Macquarie Park Data Centre (SSD-10467) - Notice of Exhibition

Thank you for your correspondence via the Major Projects Portal on 19 November 2020, requesting Transport for NSW (TfNSW) to review and comment on the above.

Scale 1:500

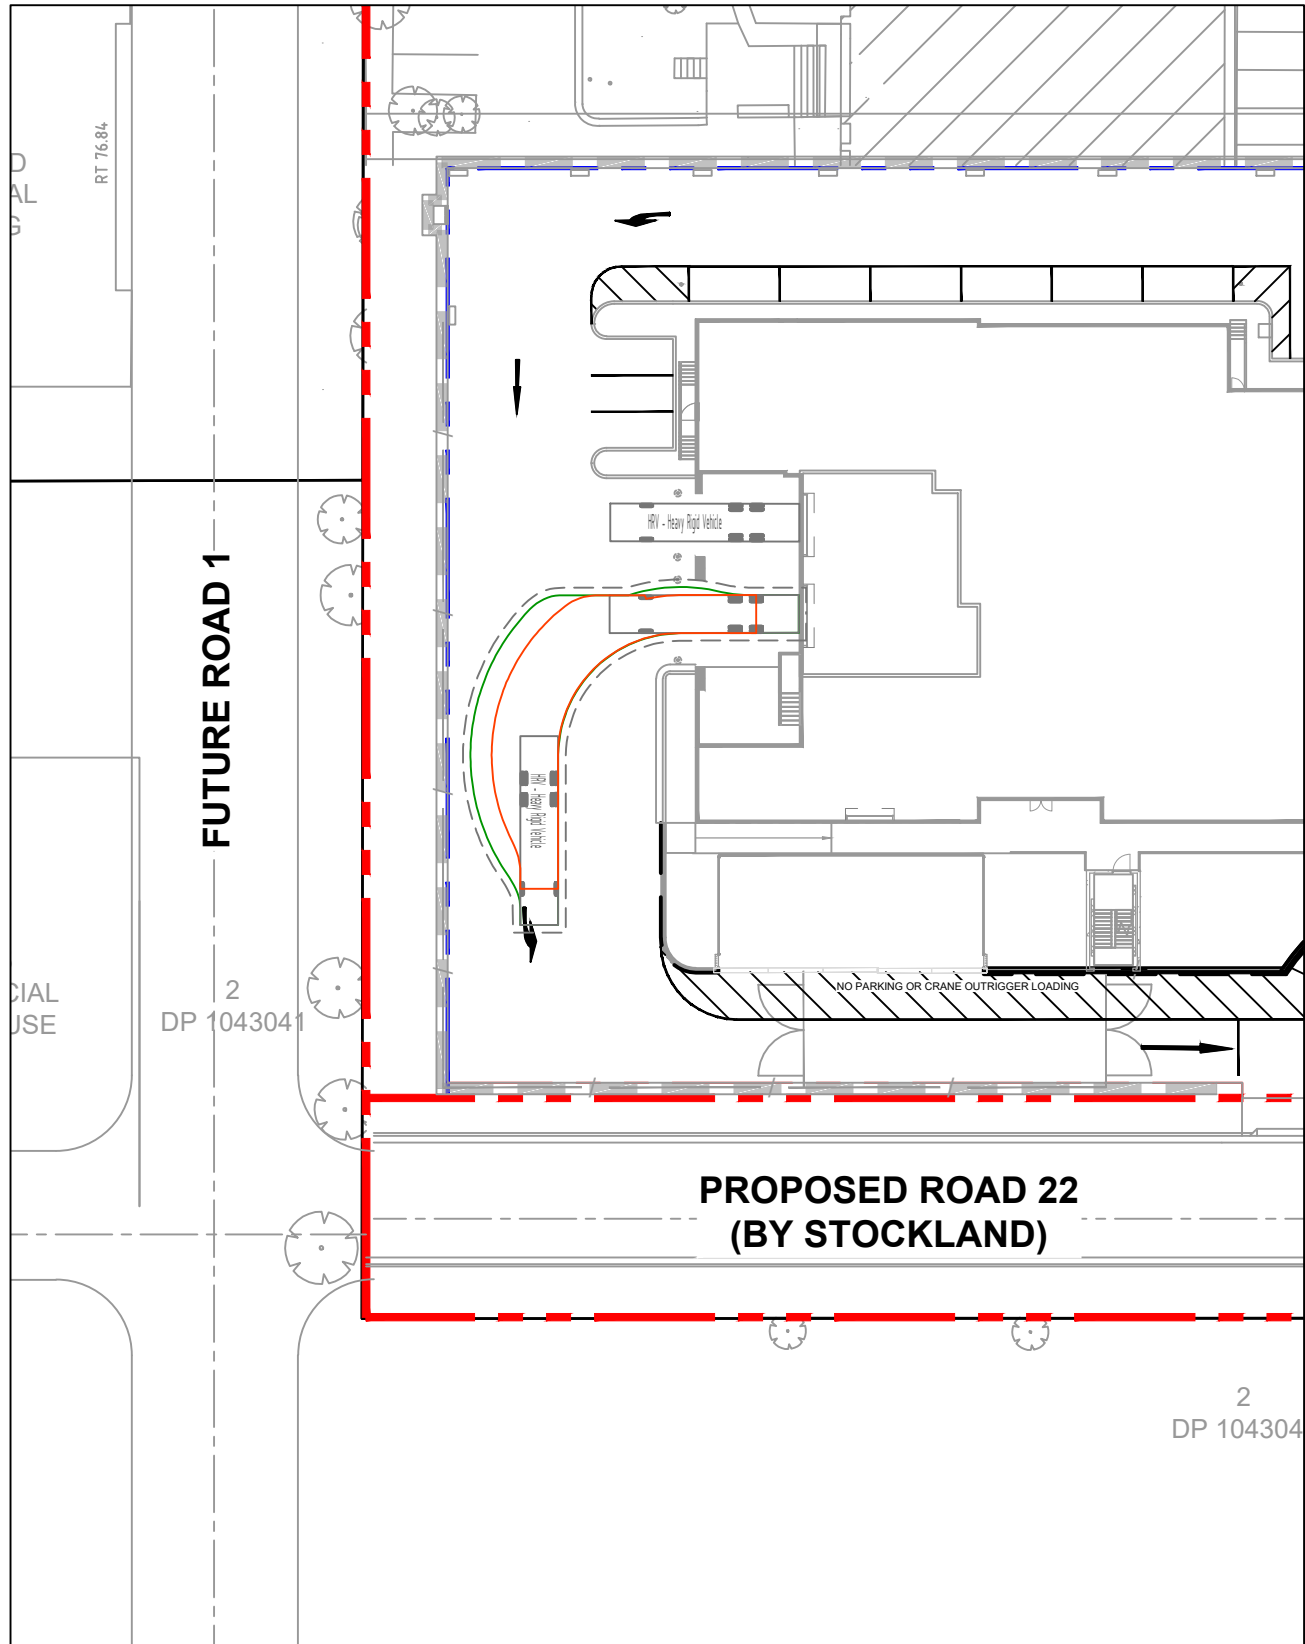
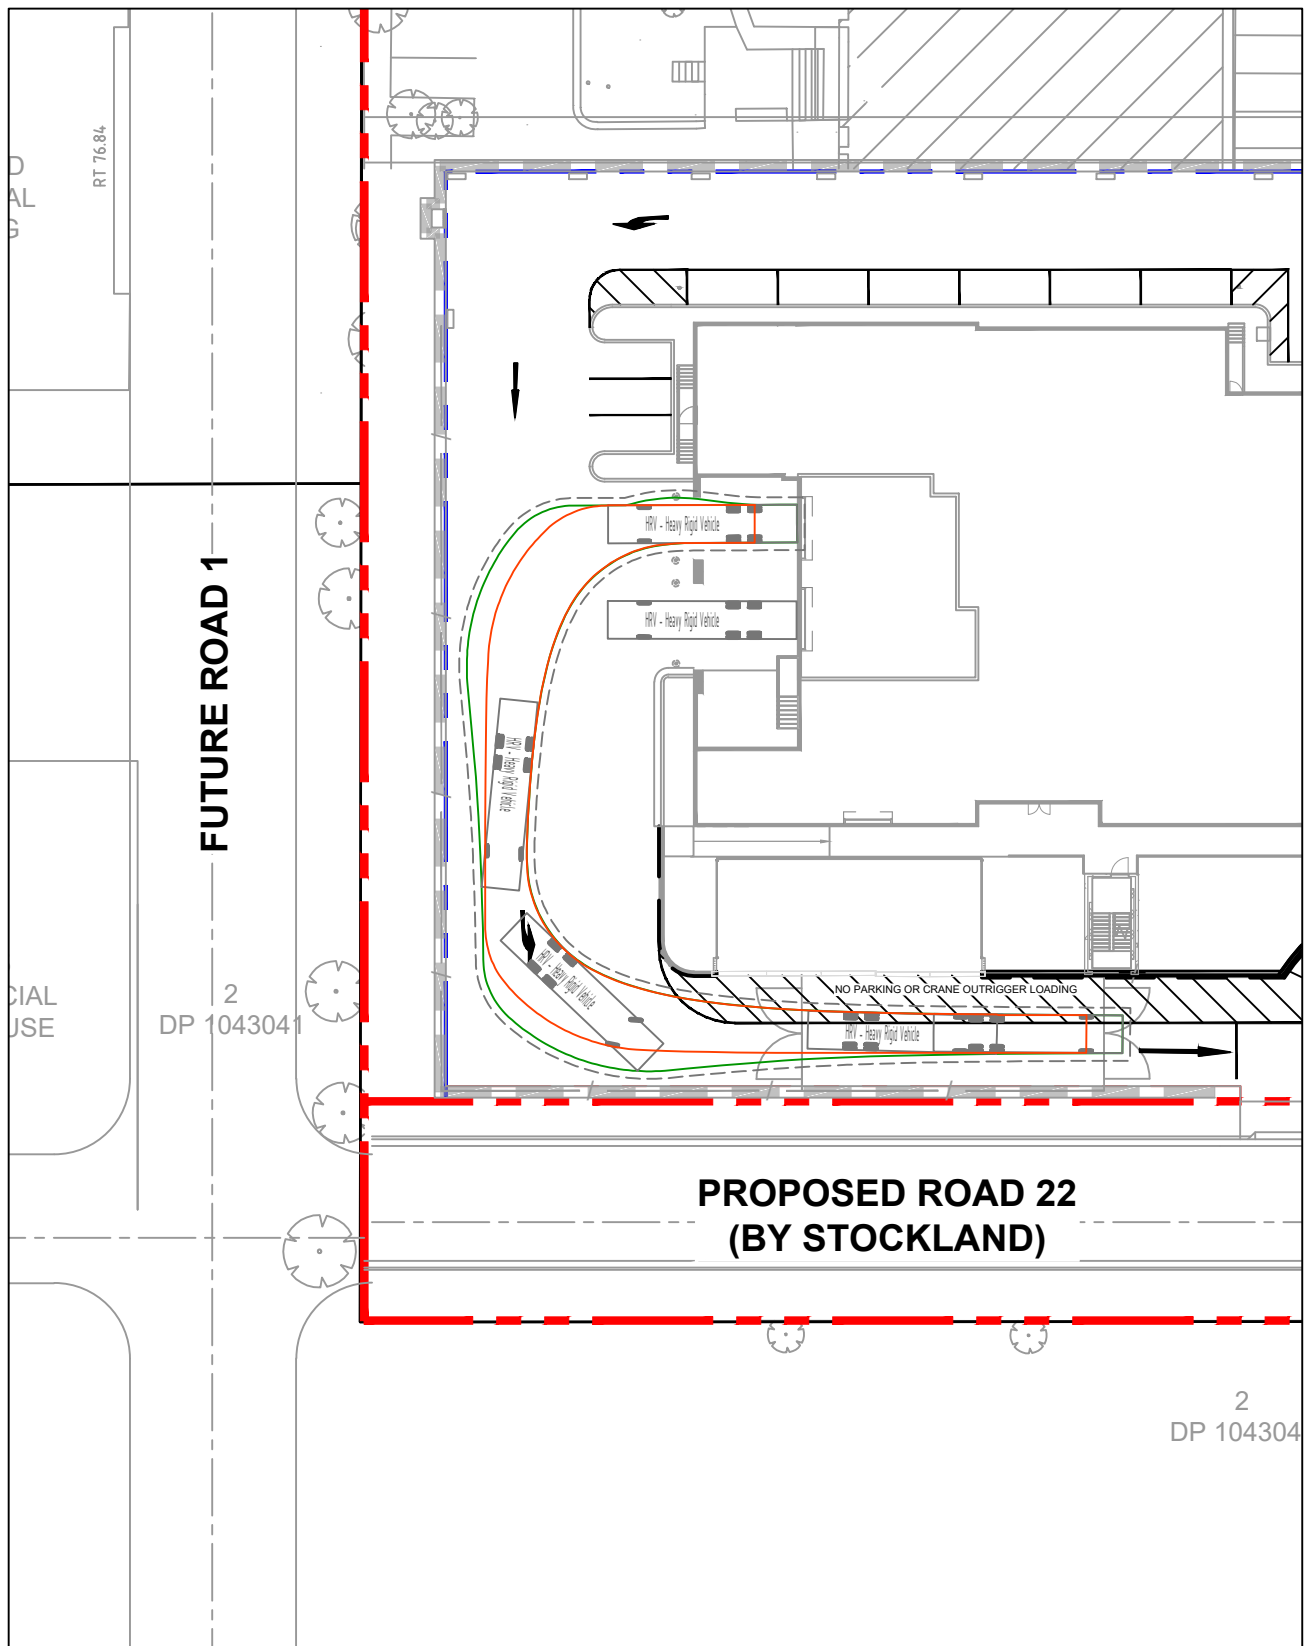
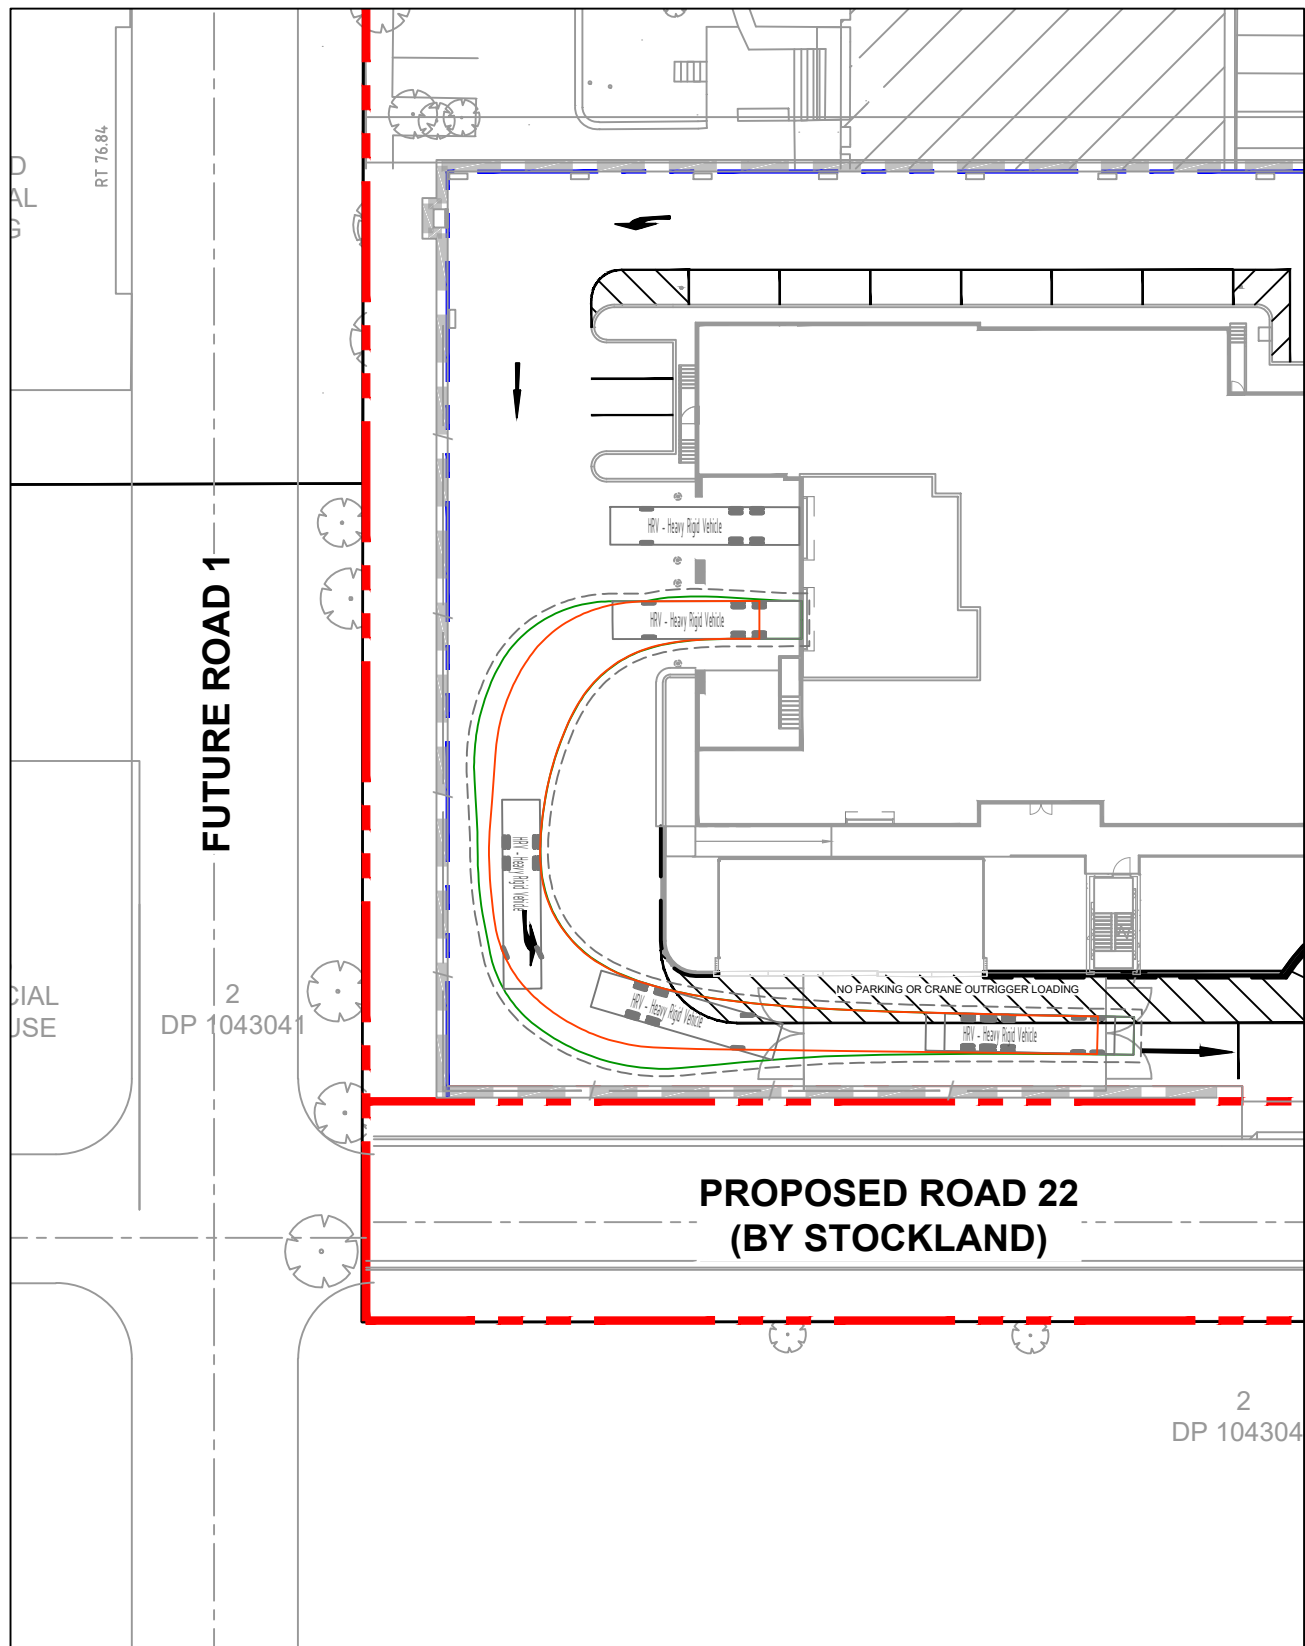
Based on the swept path analysis report prepared to support the development application, several potential conflict points are noticed between service vehicles accessing the site and the vehicles travelling opposite direction as well as pedestrian / cyclists along Road 22 and at the intersections of Talavera Road / Road 22 and Road 22 / accesses to the site. This would have the potential to cause road safety related incidents at these locations.

It is requested that the applicant procures and independent Stage 2 (Concept Plan) Road Safety Audit as part of the applicant's Response to Submissions. This should include the service vehicles access to the site along Road 22 and at the intersections of Talavera Road / Road 22 and Road 22 / accesses to the site. The audit should be in accordance with *Austroads Guide to Road Safety Part 6: Managing Road Safety Audits* and *Austroads Guide to Road Safety Part 6A: Implementing Road Safety Audits* by an independent TfNSW accredited road safety auditor.

Based on the results of the road safety audit, the applicant should review the design drawings and implement safety measures in consultation with TfNSW as required.
